**MONUMENT FIRE DISTRICT**

July 16, 2024

Ref: Society of Classical Christian Education (SocCe) Site Dev plan

The Monument Fire District has completed the review of the 7/1/2024 Walker Road and the Society of Classical Christian Education Site Development plan. We have the following comments.

SITE PLAN KEYMAP

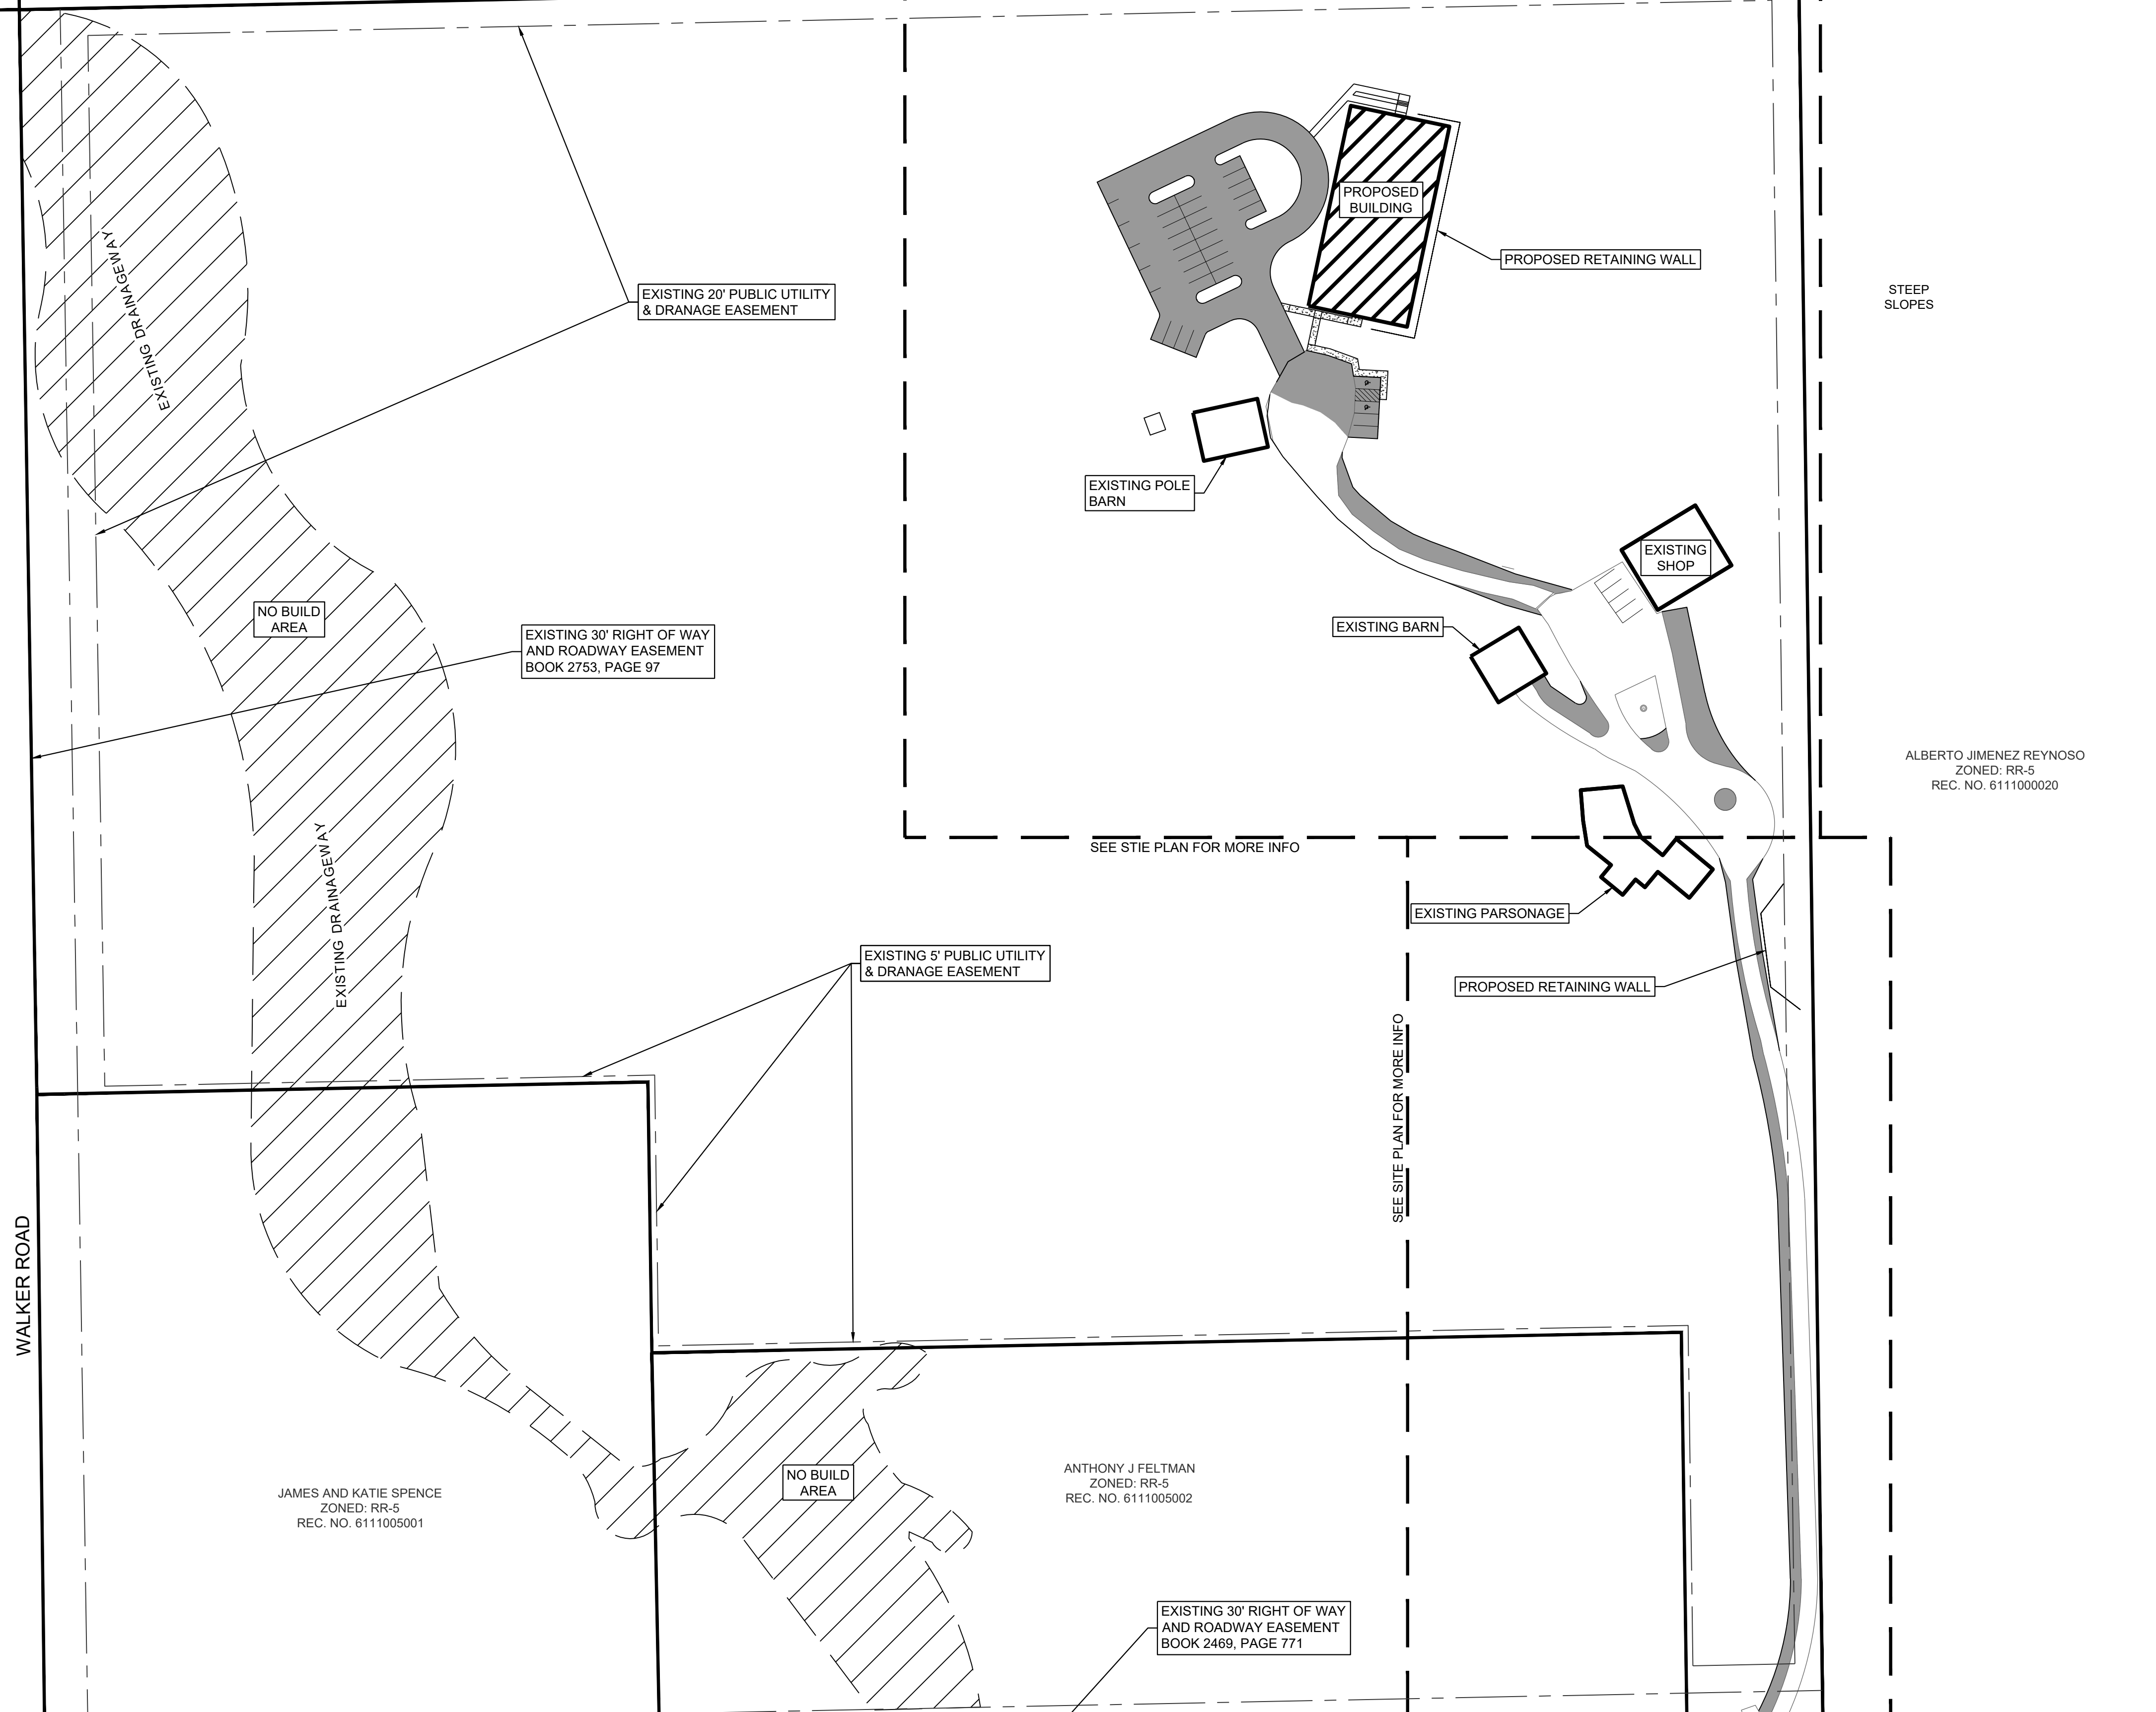
1. Fire Department Access:
  - a. The site development plan uploaded to the EDARP system on 7/1/2024 meets the fire department access requirements from Walker Rd to the building site outlined in our letter dated 3/13/24.

3. The Fire District would like to see information addressing the following issues with the access from Kerry Run to the the private Walker Rd from our letter dated 3/13/2024

*The fire department is concerned that increased traffic and fire department access on the private Walker Road may limit ingress and egress in the event of an emergency to the proposed site and for the existing properties and residents. It is recommended that the county consider EPC Land Use Code Section 8.4.4 (D1, D2, E1, E2, E3, E4), Dead-End Road Standards and Private Road Allowances, when determining if the proposed project can be effectively served by this road. The private Walker Road may need to be either widened, or a second access road may need to be provided. In addition, the fire department requests that the county facilitate a name change of the private Walker Road to eliminate confusion with the nearby public Walker Road.*
